Date: 13 March 2020

Planning Act 2008 – Section 89 and The Infrastructure Planning (Examination Procedure) Rules 2010 – Rule 8(3) and 17

Application by Norfolk County Council for an order granting development consent for the Great Yarmouth third river crossing project.

DRAWN	CHECKED	APPROVED	AUTHORISED
AK	JW	TJ	MK

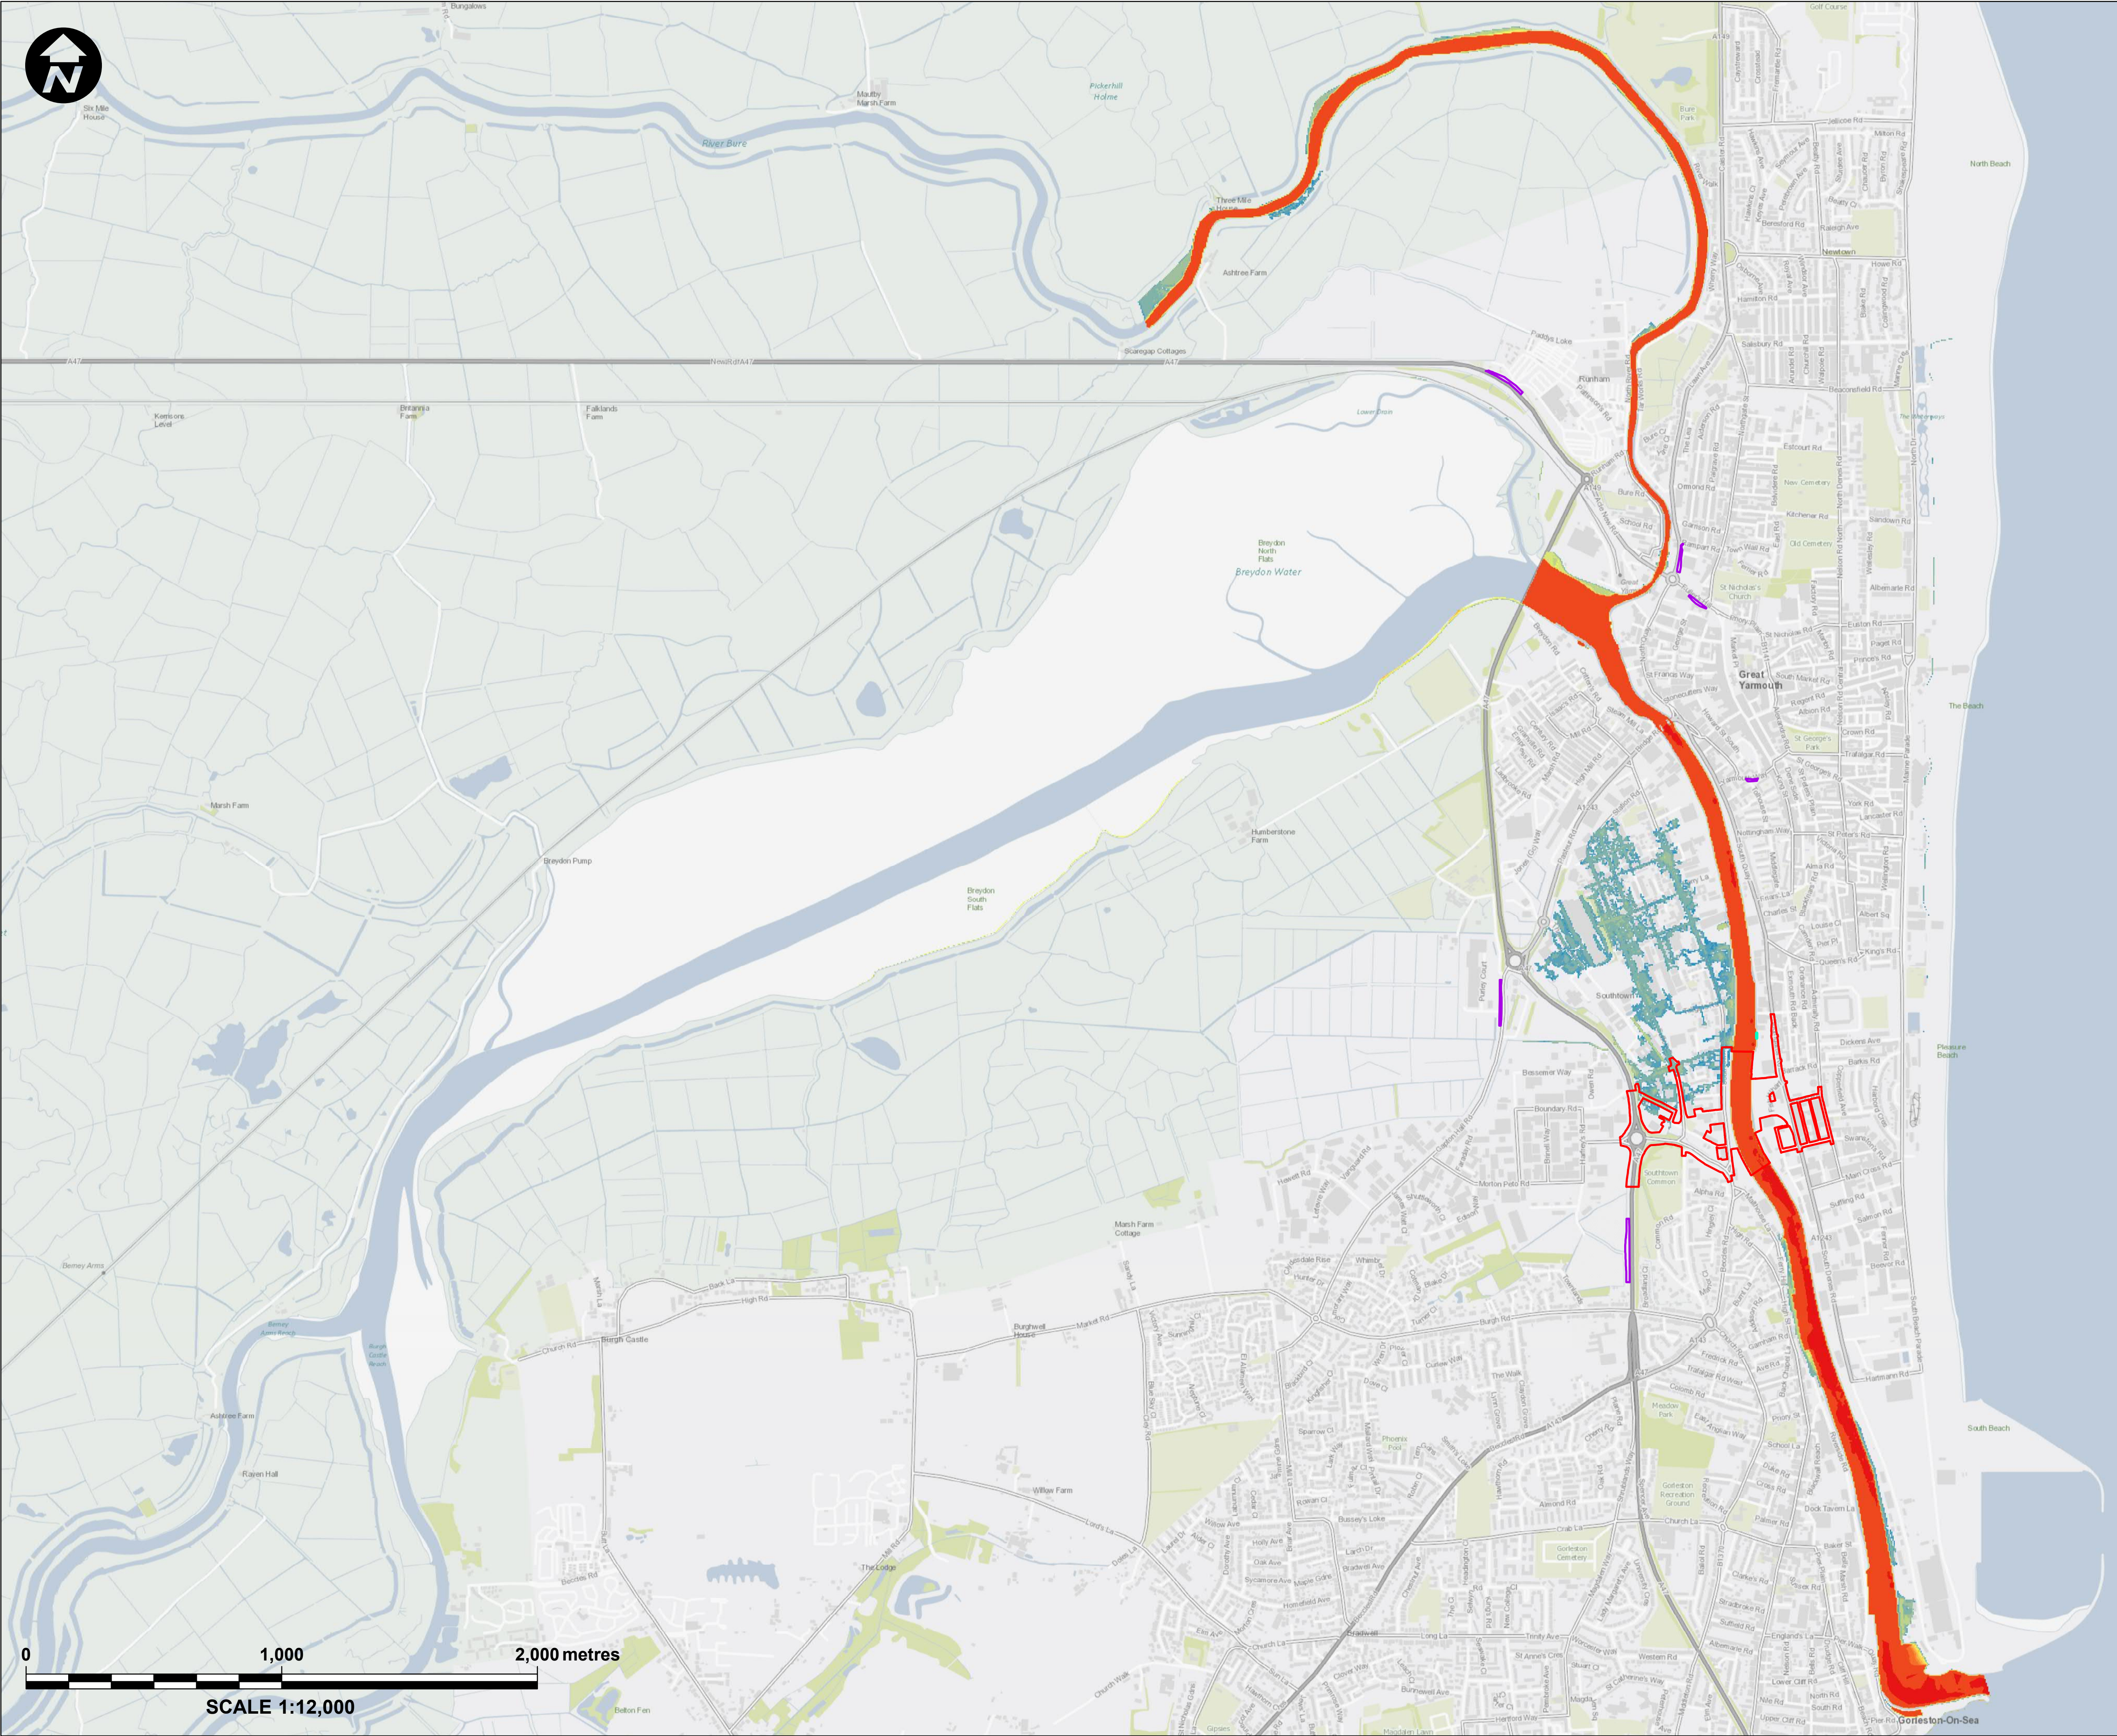
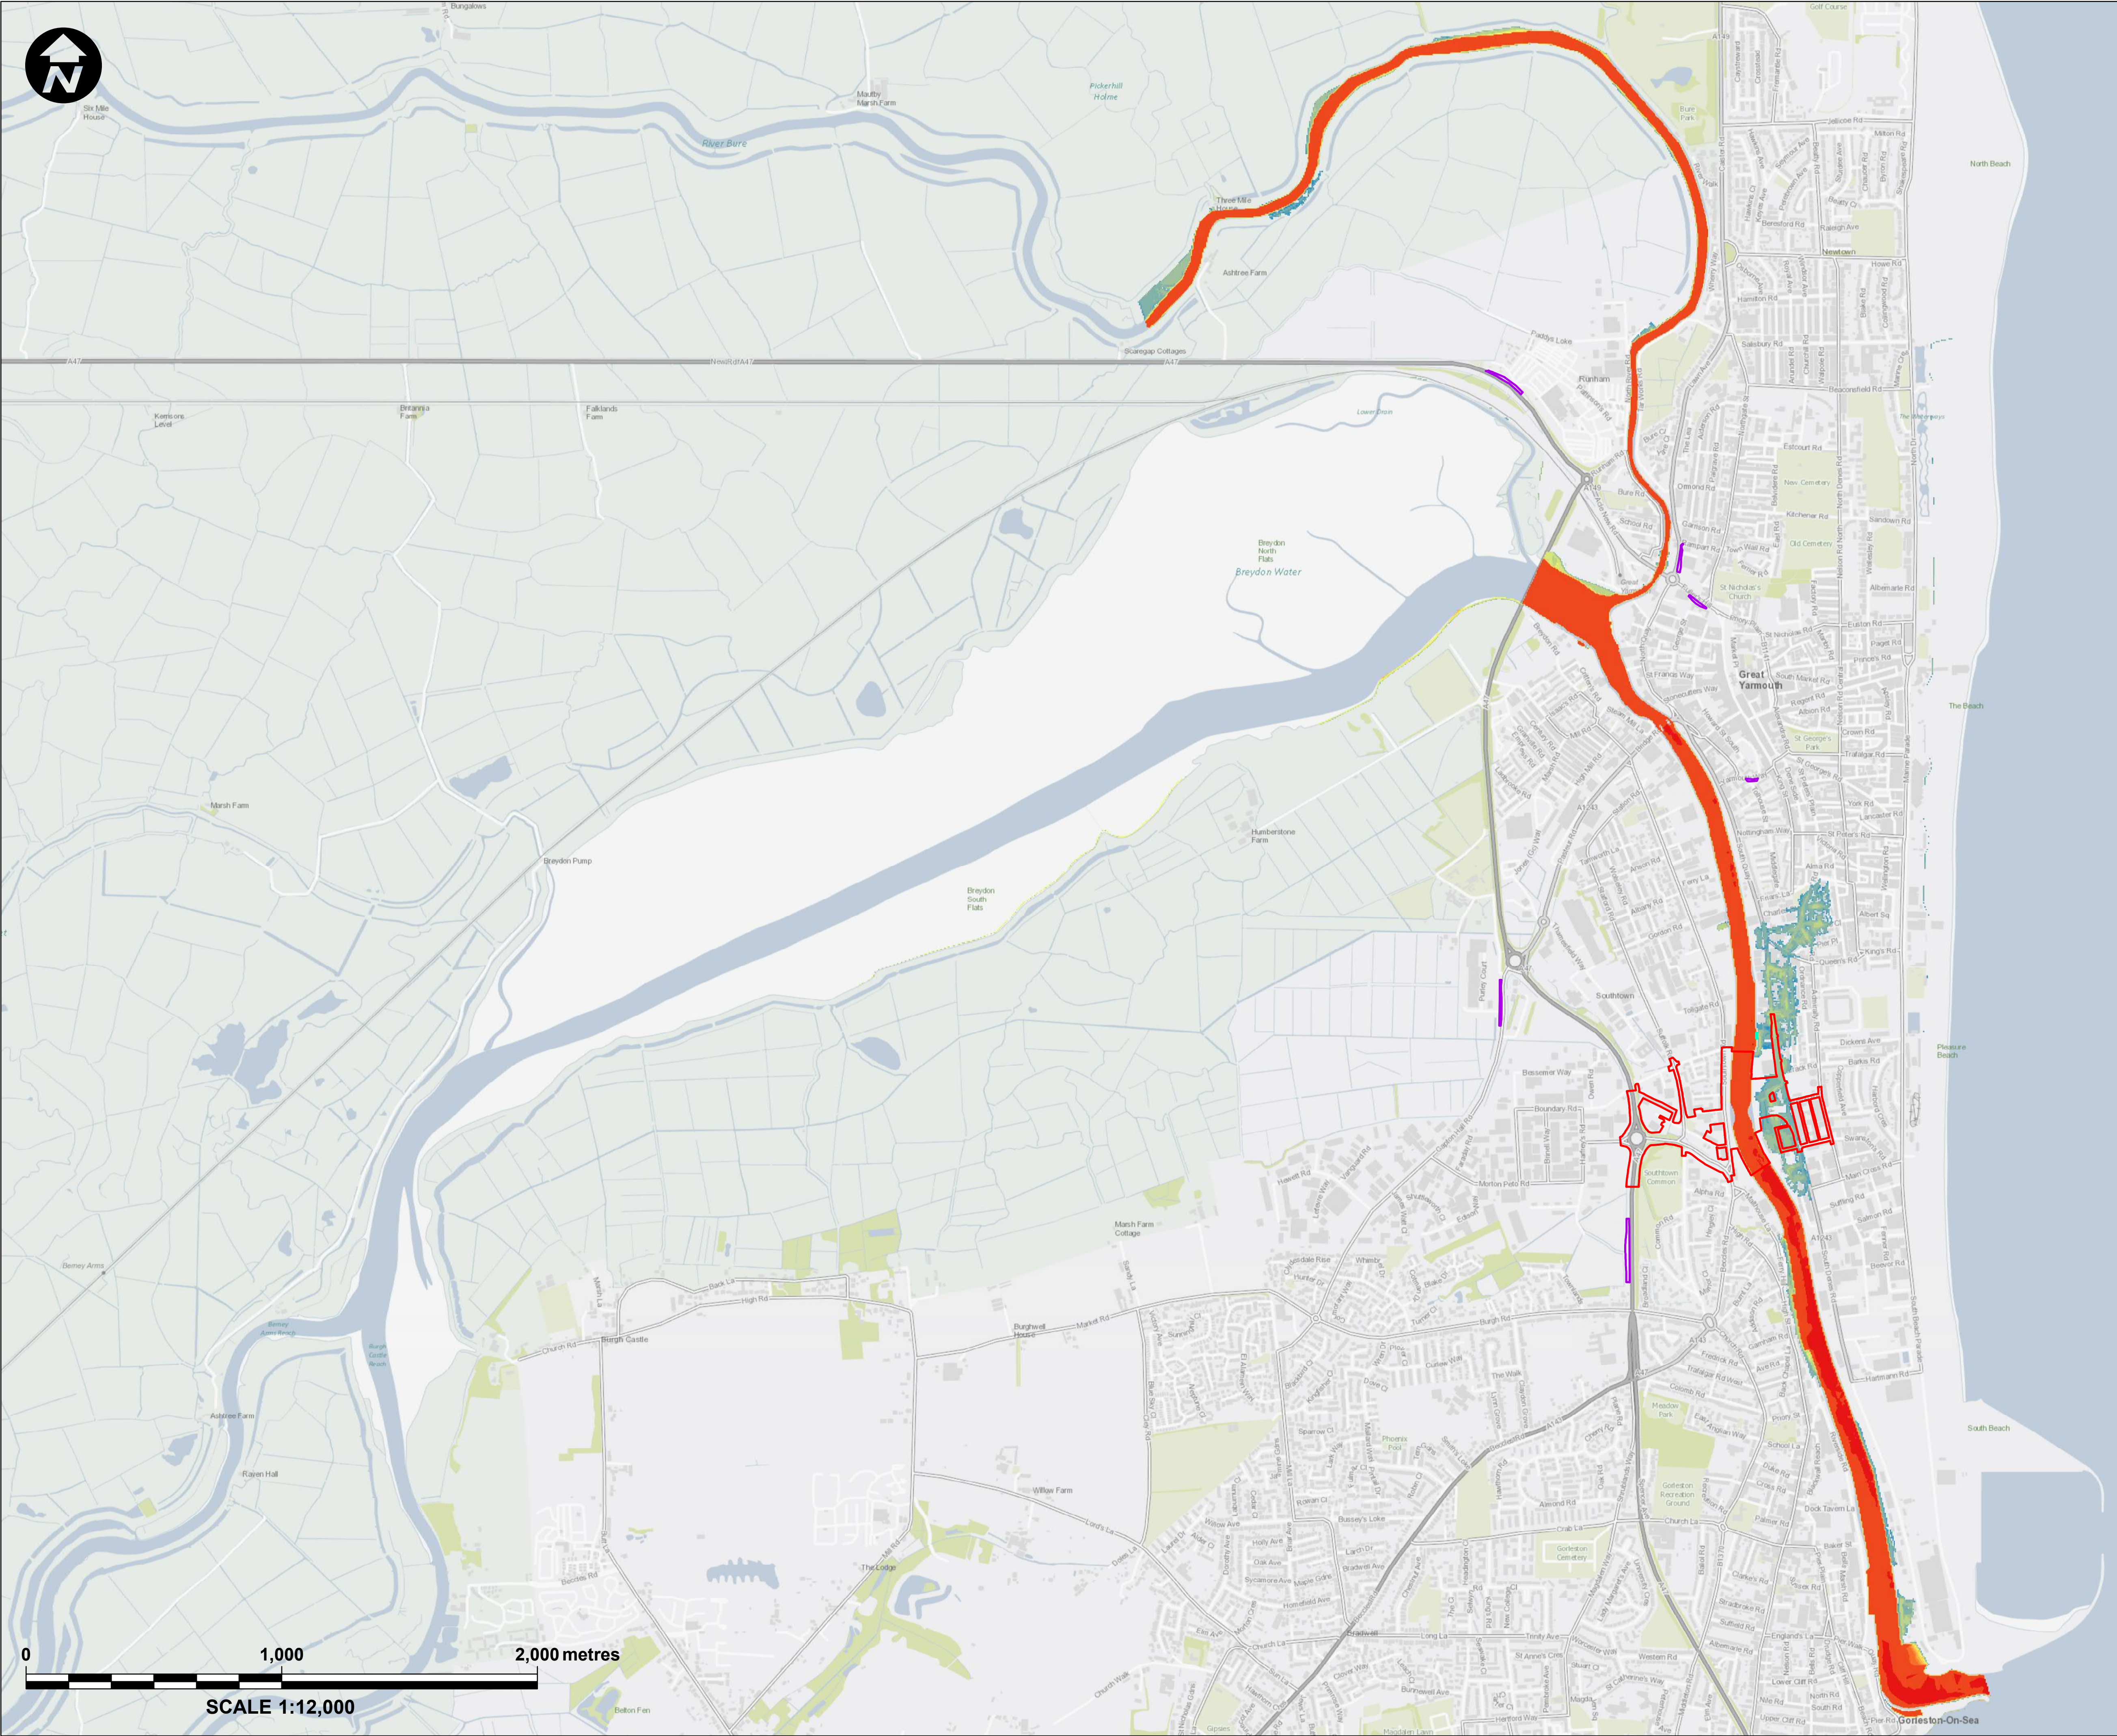
However, the figures used in the tidal residual (breach) risk analysis to show the difference in flood depth do not provide information that matches all the flood extents identified. Until this information is analysed and presented as part of the FRA the ExA is not informed regarding the change in hazard to third parties arising from the proposed development in the event of breach.
